Our ref: RA/2019/139982/01-L01
Your ref: 19/00333/FULL
Date: 26 April 2019

APPLICATION FOR FULL PLANNING PERMISSION FOR THE DEMOLITION AND PARTIAL REBUILDING OF THE EARL DE GREY PUBLIC HOUSE; ERECTION OF LINK EXTENSION TO CASTLE BUILDINGS AND THE EARL DE GREY; EXTERNAL ALTERATIONS TO CASTLE BUILDINGS; USE OF RELOCATED EARL DE GREY, CASTLE BUILDINGS AND LINK EXTENSION FOR CAFÉ OR RESTAURANT (A3) AND/OR DRINKING ESTABLISHMENT (A4) AND/OR OFFICE (B1A); THE ERECTION OF A NINE-STOREY HOTEL; NEW PUBLIC REALM AND ASSOCIATED WORKS, INCLUDING LANDSCAPING, CAR PARKING AND SERVICING, AND ASSOCIATED INFRASTRUCTURE. LAND TO THE NORTH OF CASTLE STREET AND SOUTH-EAST OF WATERHOUSE LANE, INCLUDING CASTLE BUILDINGS AND THE EARL DE GREY PUBLIC HOUSE KINGSTON UPON HULL HU1 2DA

Flood Risk

Figure 11: Abstract from Hull SFRA 2016 Figure 13 Exception Test Information

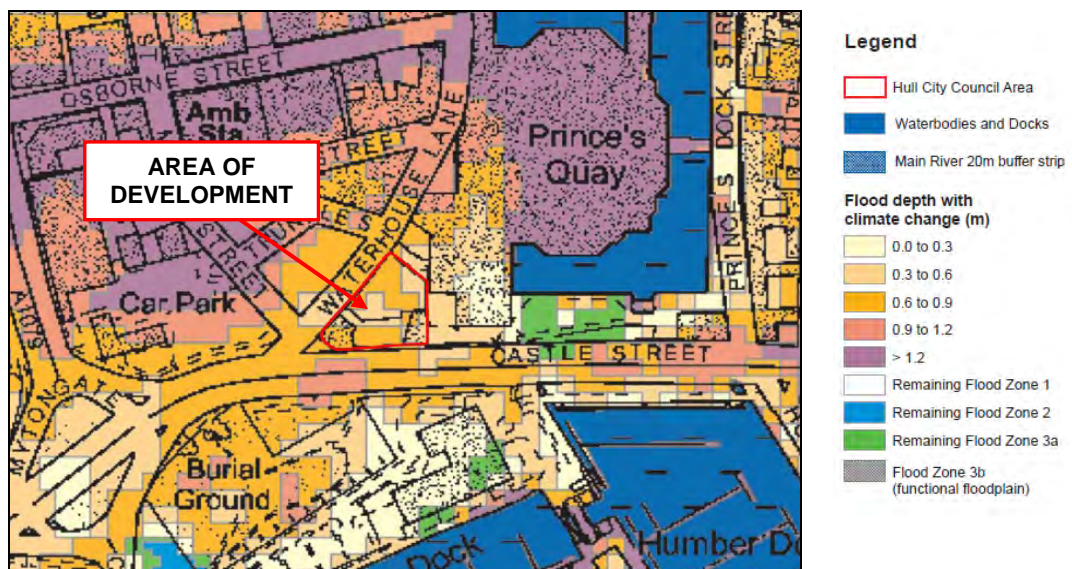
Where a development site encapsulates a range of different depth categories, the applicant should assume the greatest depth present and add this to the average site level or road frontage level, whichever is highest. The average site level should be calculated based on a representative range of spot heights across the site. The road frontage level is calculated as the average between the gutter and crown of the road. Where there is a choice of adjacent roads, the highest should be chosen. The resulting value should be added to the highest predicted flood depth on this site, which according to figure 13 of the Hull Strategic Flood Risk Assessment (SFRA) 2016 is 900mm.

Once the flood depth has been accurately predicted, the applicant should raise finished floor levels to exclude the predicted flood water. Where it can be demonstrated that finished floor levels cannot be sufficiently raised, other passive resistance measures may be considered to exclude water up to the predicted flood depth. This is a requirement for all new and change of use developments proposed on this site including the Earl De Grey relocation.

In addition, the applicant has incorrectly assessed the flood risk mitigation required by assuming the development must be raised 600mm above the predicted flood depth. For this development, flood resistance measures are required up to 900mm above the average site level or adjacent road frontage level, whichever is highest. Further flood resilience measures should be included to a minimum of 300mm above finished floor levels. There is no requirement for an additional 600mm of raised floor levels as incorrectly stated in the submitted FRA.
